# CITY OF ALBUQUERQUE

January 11, 2018

**RE: Lot 5 Block 8 Unit 22 SAD 228  
Volcano Cliffs Subdivision  
6412 Canavio St NW  
Request for Permanent C.O. – Not Accepted  
Engineers Stamp Date 5/24/17 (D10D003E5)  
Certification Dated: 1/10/18**

GRADING & DRAINAGE PLAN  
6412 Canavio Place NW  
LOT 5, BLOCK 8, UNIT 22 VCS

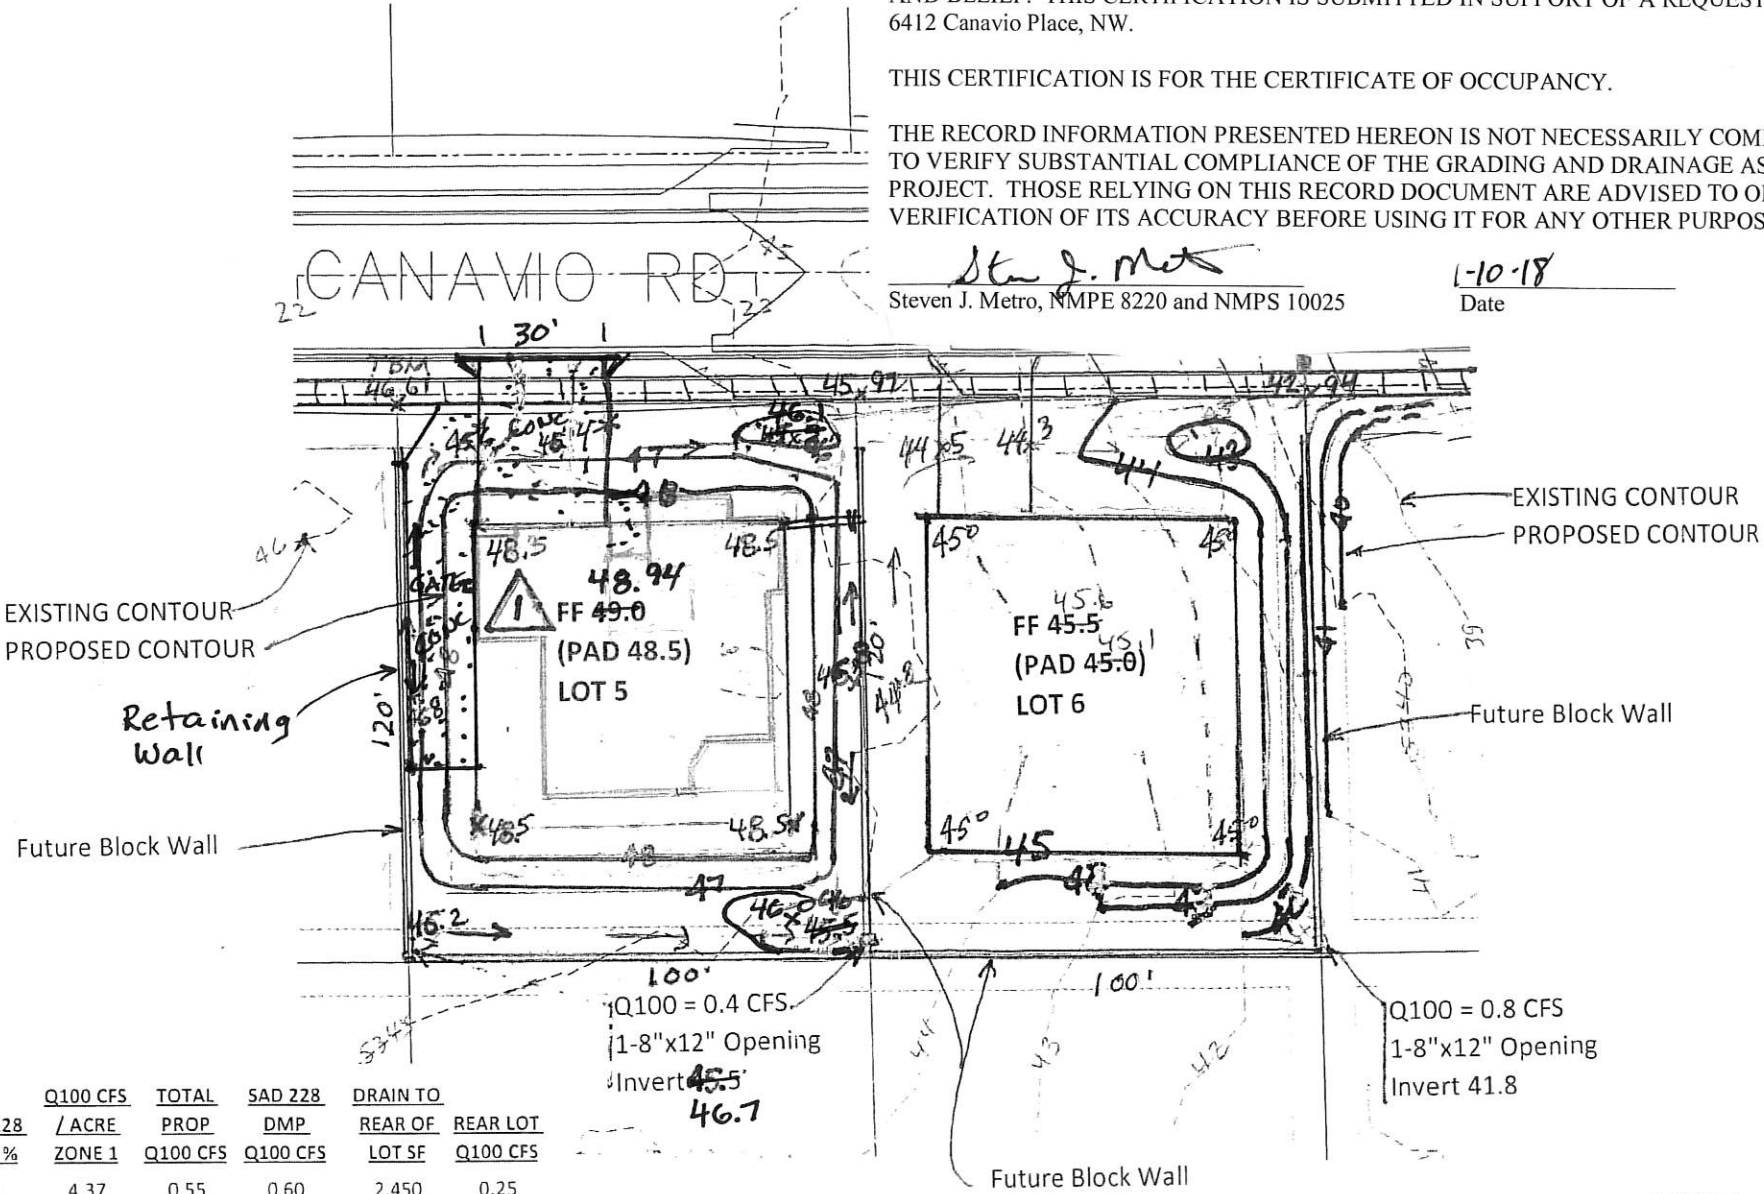
- An opening in the block fence, on the west side of the property, must be provided, according to the approved plan dated 5/24/17.
- All dirt piles, debris and concrete must be removed in and around the entire site.
- The dumpster located on the west side of the property must be removed.
